EPA Assessment of SSD 9505 – Regis Resources McPhillamy Gold Project Environmental Impact Statement

ATTACHMENT A: Regis Resources McPhillamy Mine EIS
EPA Comment

Figure 3
Receiver Locations

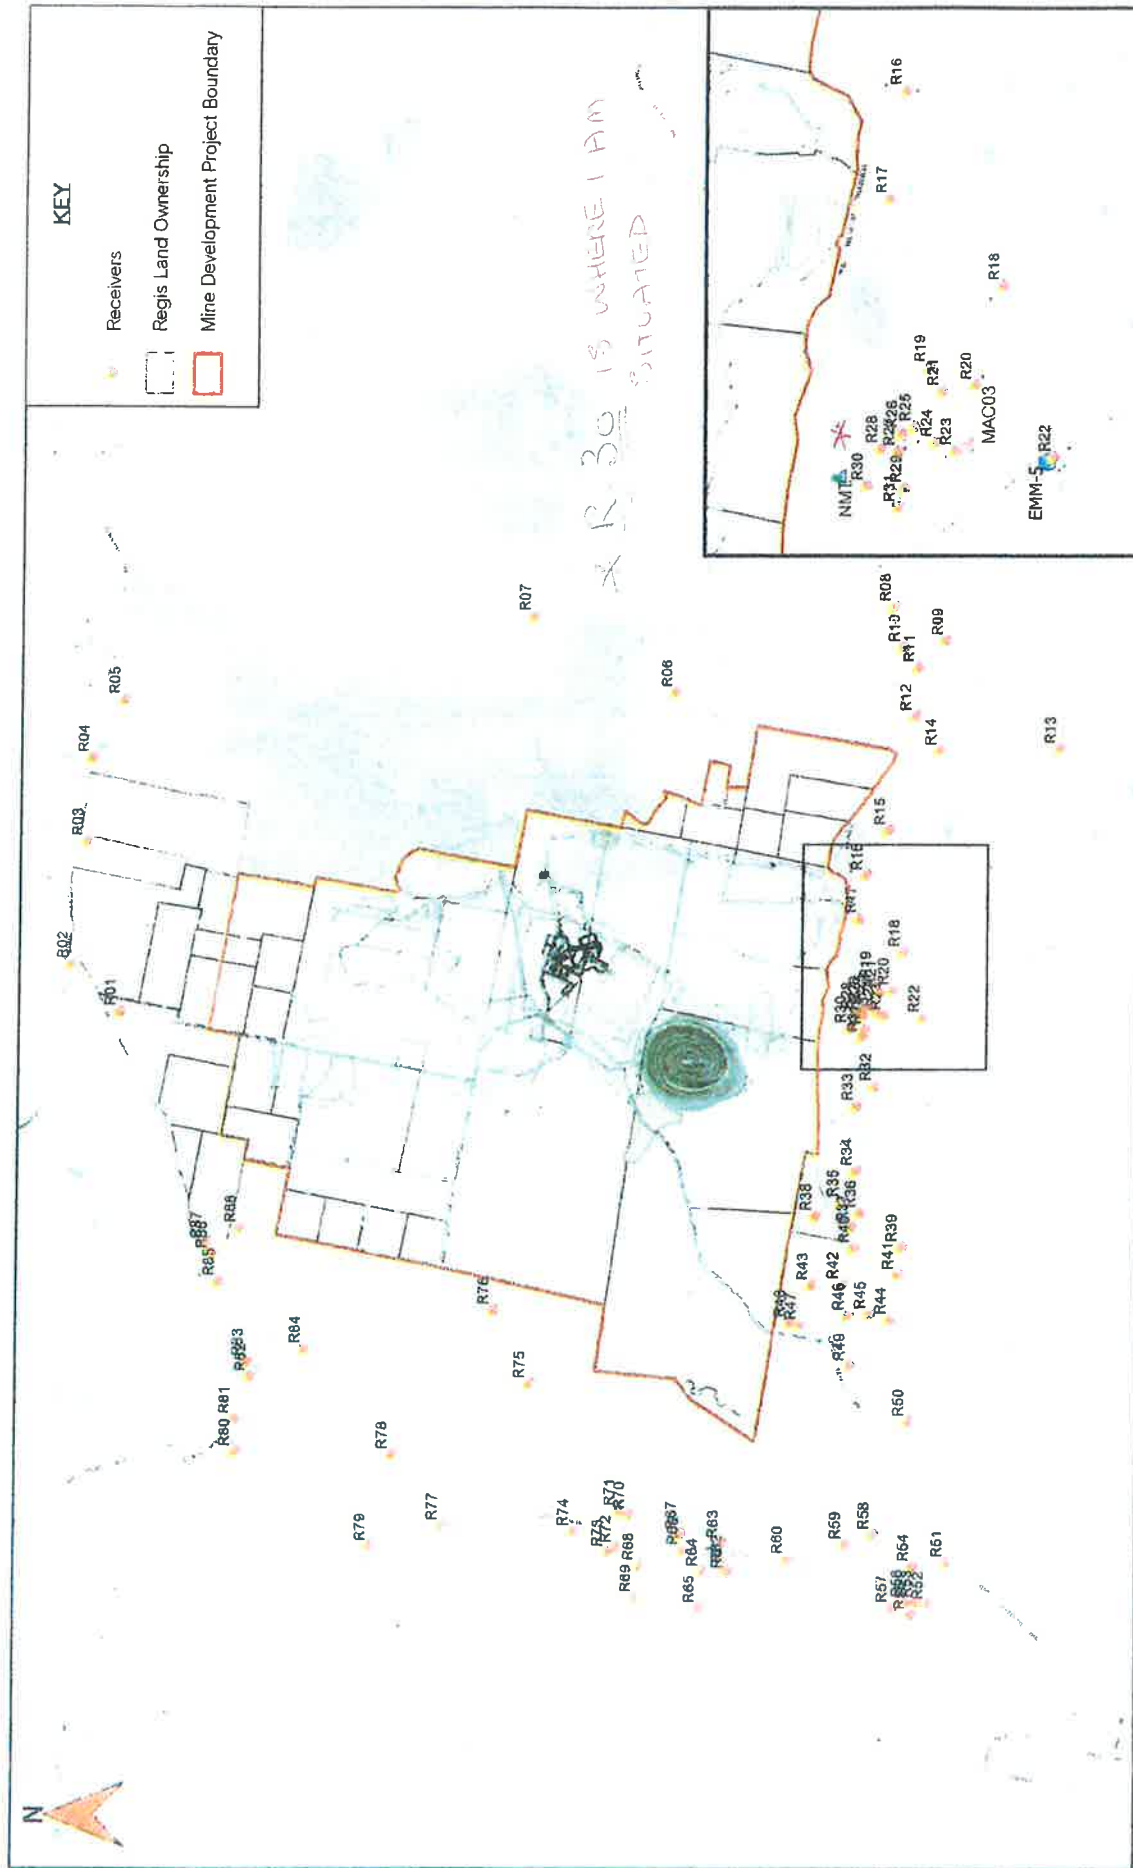
A review of a selection of the nominated receiver locations in Table 1 of the noise report indicates that the receivers have not been assessed in a location consistent with NPfI Section 2.6 which states:

For a residence, the project noise trigger level and maximum noise levels are to be assessed at the reasonably most-affected point on or within the residential property boundary or, if that is more than 30 metres from the residence, at the reasonably most-affected point within 30 metres of the residence, but not closer than 3 metres to a reflective surface and at a height of between 1.2–1.5 metres above ground level.
